From: Laura Gibbons <Laura.Gibbons@arun.gov.uk>
Sent: 30 March 2022 14:56
To: Planning.Responses <Planning.Responses@arun.gov.uk>
Cc: David Easton <David.Easton@arun.gov.uk>
Subject: RE: Planning Consultation on: P/22/22/PL

Engineers Comments Regarding Surface Water Drainage

Application No: P/22/22/PL

Site Address: Land West of Hook Lane Pagham PO21 3PB

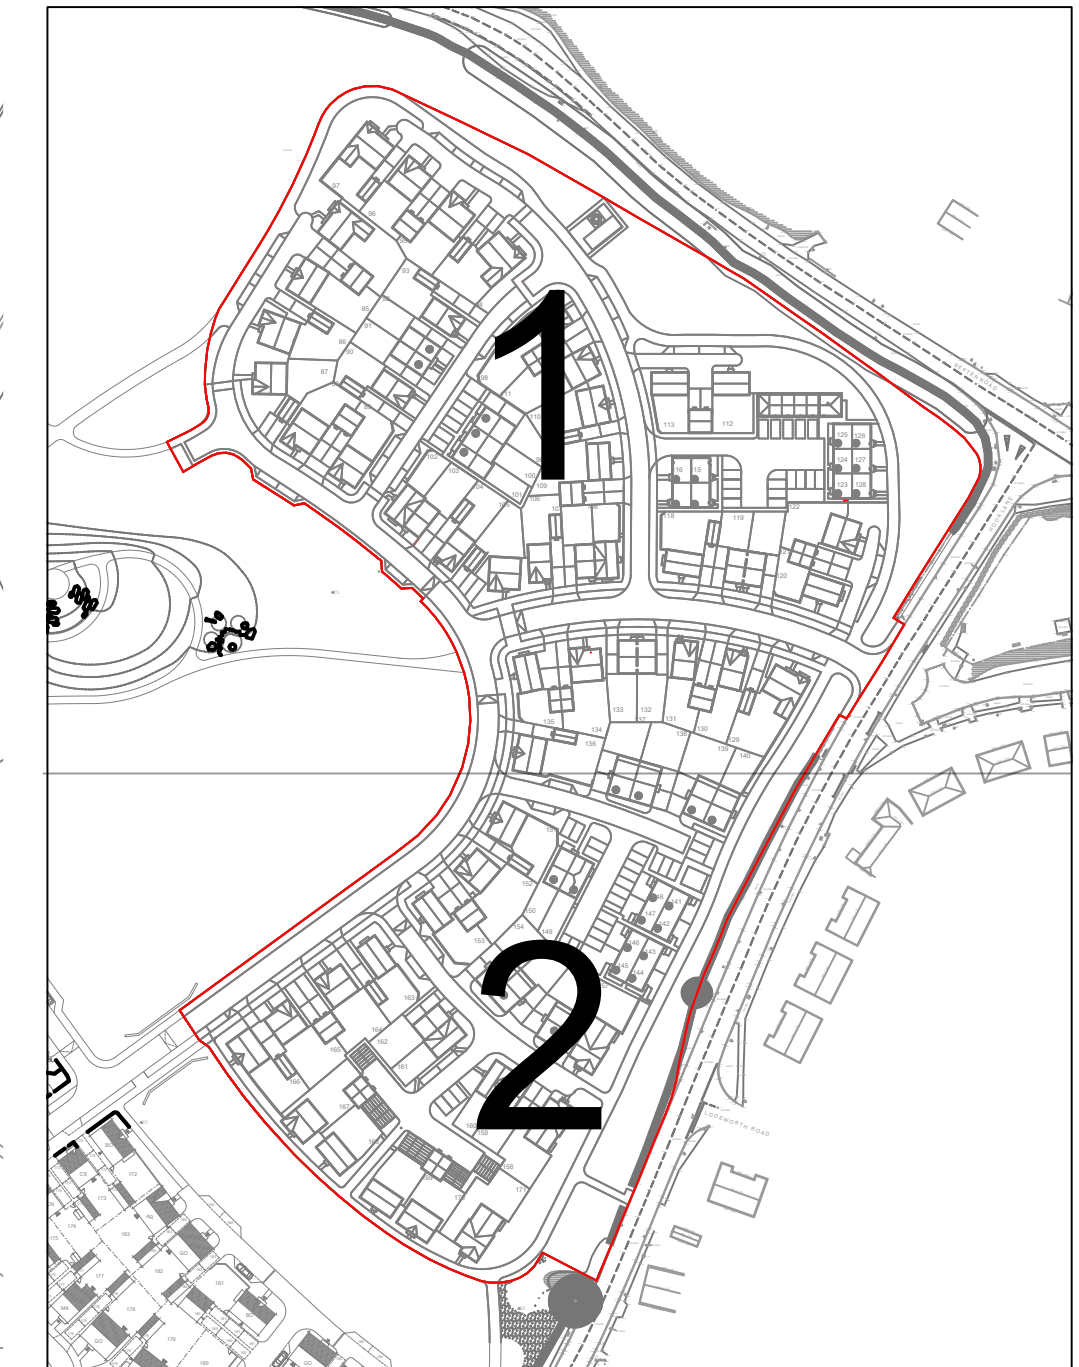
Landscaping will need to be reviewed at later stages to ensure that tree root potential areas do not conflict with existing ordinary watercourses, or proposed surface water drainage features.

Drainage Strategy Plan

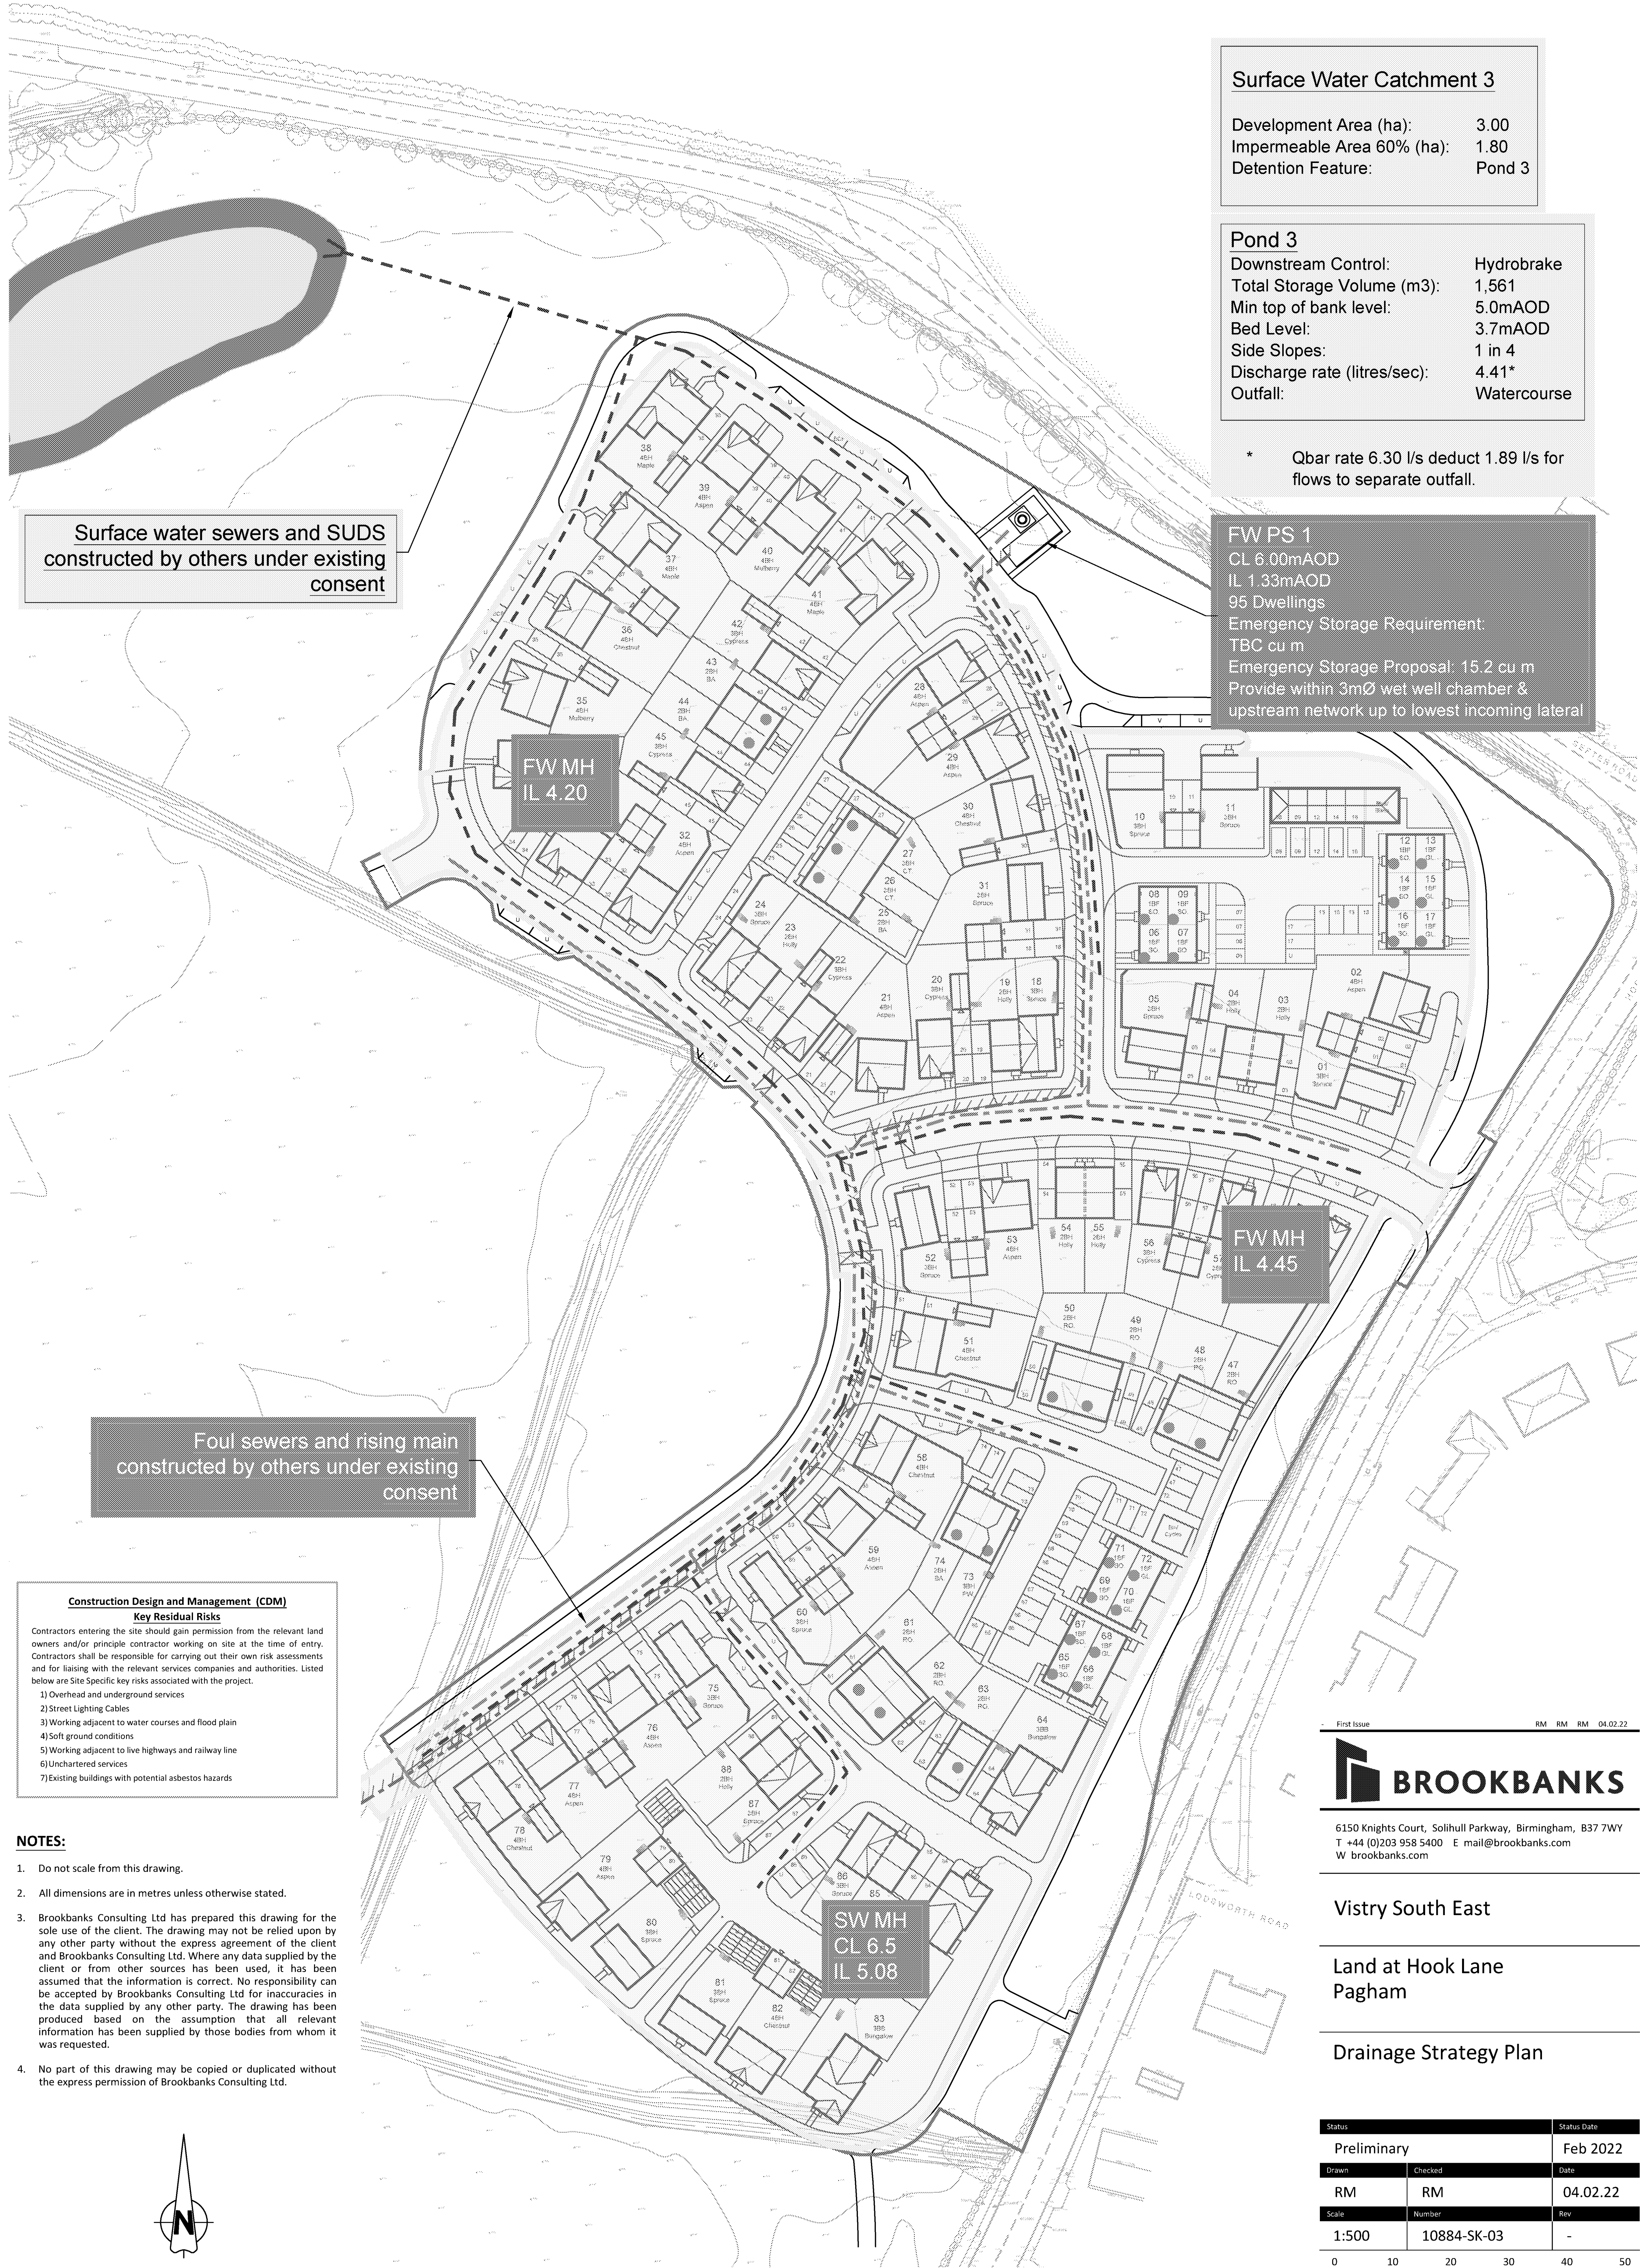
A separate application to discharge the surface water drainage conditions will be required. If you are minded to approve this application please do not list the flood risk assessment, drainage strategy or drainage strategy plan as approved.
